# Office of Environment & Heritage

**RE: Cobbora Coal Project Preferred Project Report and Response to Submissions for public exhibition**

13 March 2013

## ATTACHMENT 1 - Biodiversity

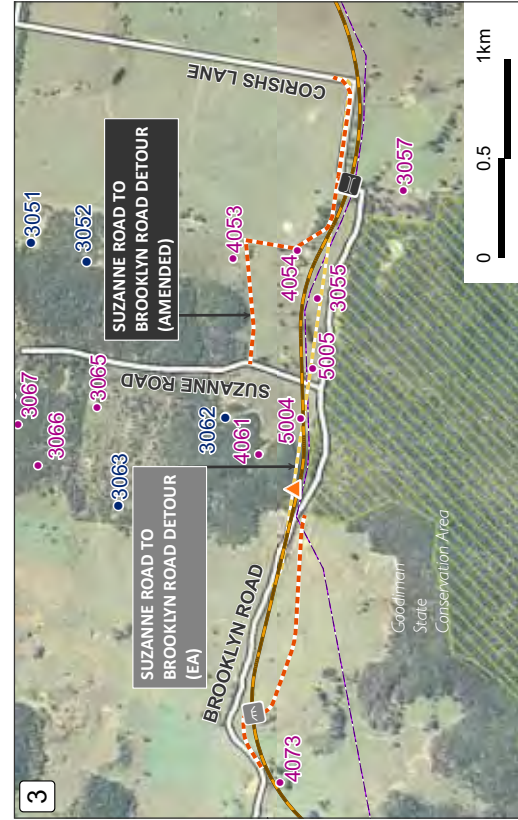
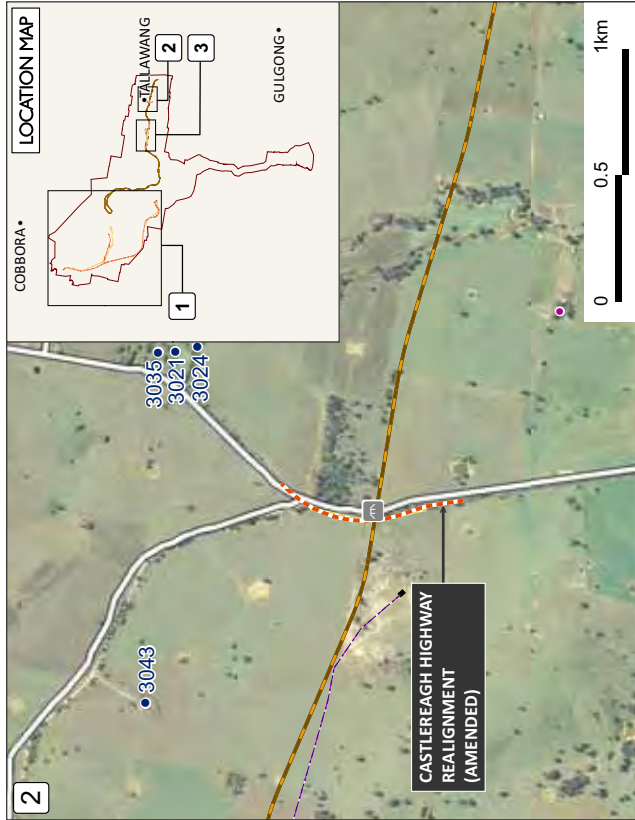
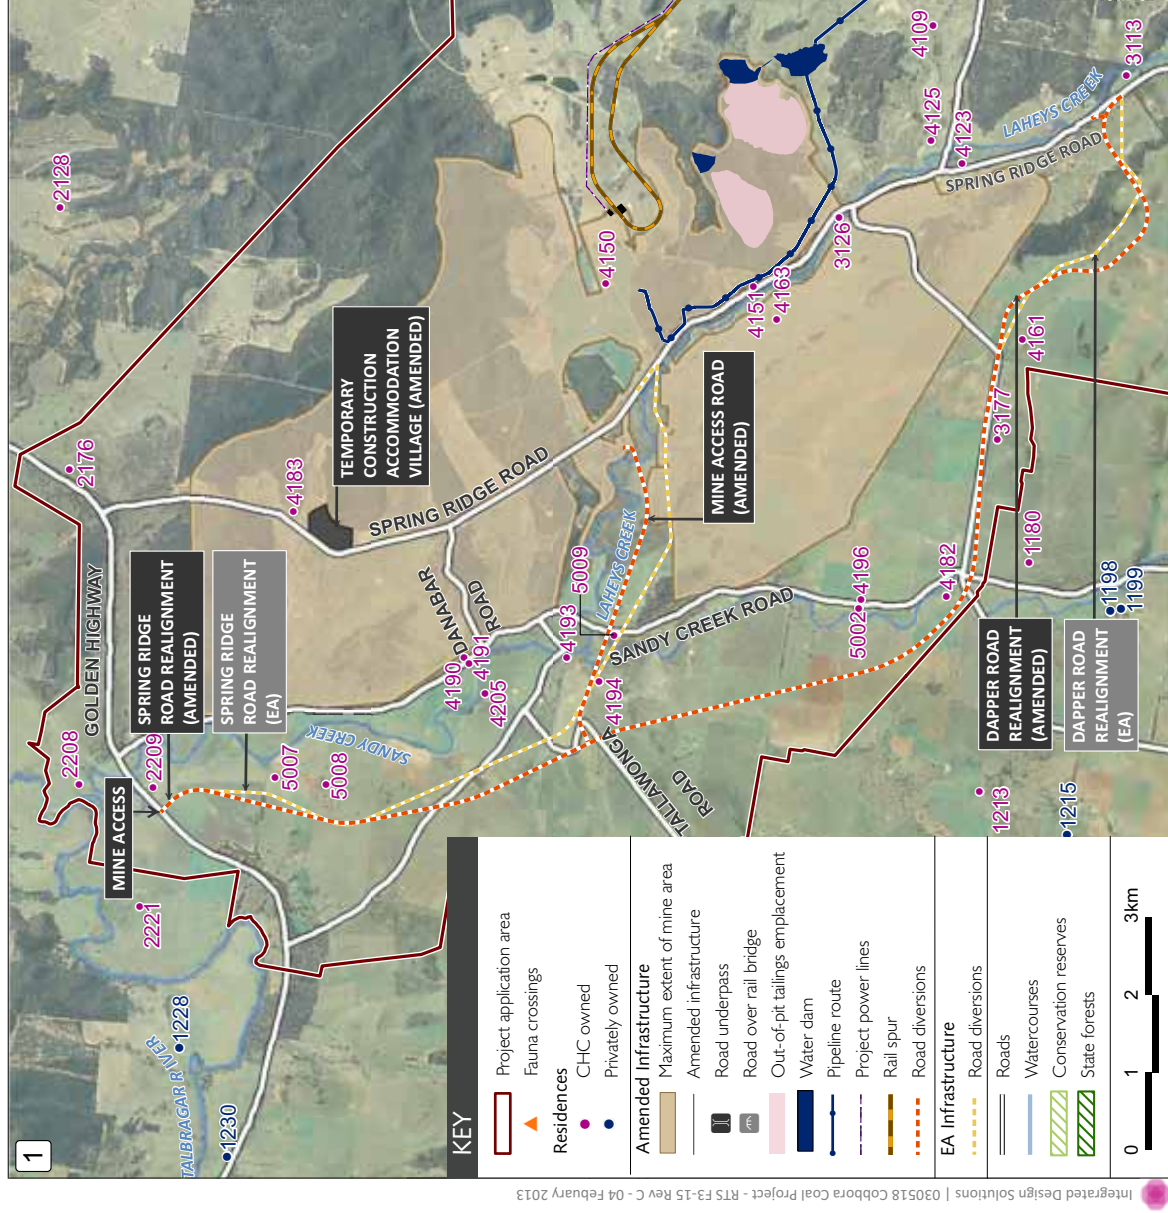
Section 3.9.5 (p. 37, volume 1) twice refers to an underpass on the **west** side of Goodiman SCA. When travelling 'east from Corishs Lane to Brooklyn Road' a 'new section of road and a road over rail bridge will take Brooklyn Road over the rail spur and back onto its existing alignment'. The text indicates that it is the underpass on the west side of the SCA that will maintain access to both the SCA and a residence (3044, not marked on this map) to the east of the SCA. Figure 3.15 is referred to.

There seems to be a mistake with either the text or the map in Figure 3.15. Contrary to the text the map indicates an underpass to the **east** of the SCA and a road over rail bridge to the west of the SCA. The text appears to reverse these. It is not clear which is correct.

- Clarify the location of the road over rail bridge and rail underpass in the vicinity of Goodman SCA.
- Provide the additional noise assessments undertaken for the Goodman SCA.
- Provide information on the likely indirect impacts of the proposal on OEH Estate and proposed offsets, including noise, light spill and dust; in particular the likely level of mitigation expected to be achieved and the types of measures that could be employed.
- Employ the methodology set out in the BioBanking Operation Manual to take into account any residual indirect impacts on biodiversity values after considering the likely efficacy of available mitigation measures.
- Consult directly with OEH (National Parks and Wildlife Service) to refine the CHC commitments with regard to fire management.

Vegetation Types in the Secured Offsets

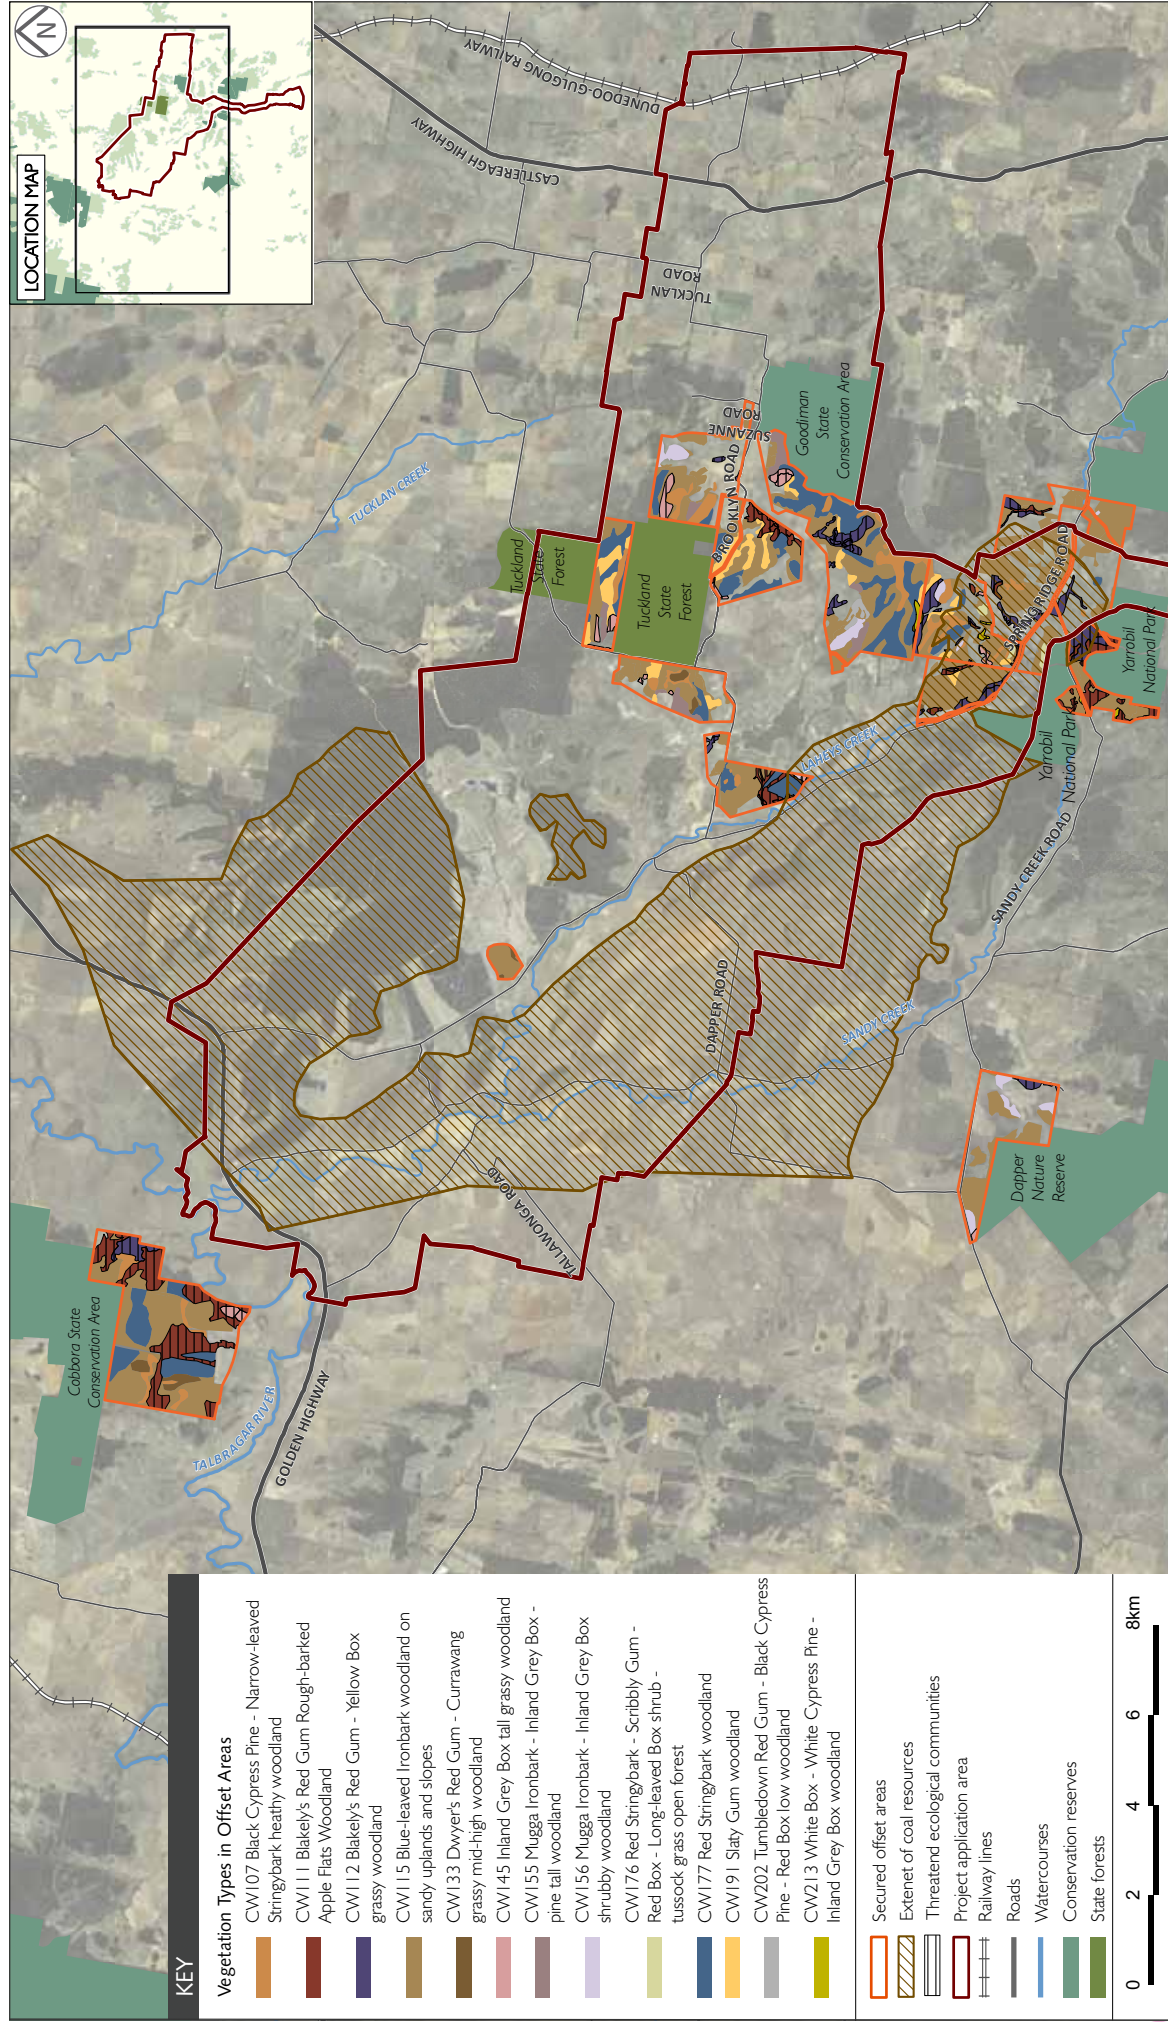
Some additional properties have been included in the offset strategy since the EA exhibition. However it also seems that there are some properties which formed part of the original offset strategy as described in the EA, which no longer appear in the PPR. The reasons for this are unclear, particularly where these have been identified as CHC owned lands which lie outside of the mapped coal resource and on which a number of suitable vegetation types have been mapped, including areas of Inland Grey Box EEC (properties adjoining the western boundary of the northern portion of Tuckland State Forest for example). The proponent does state (p 31. Appendix F) that an additional 2,500 ha is already being negotiated for addition to the offset strategy however this appears to be a reference to the 'unsecured' properties hatched on Figure 3.1.
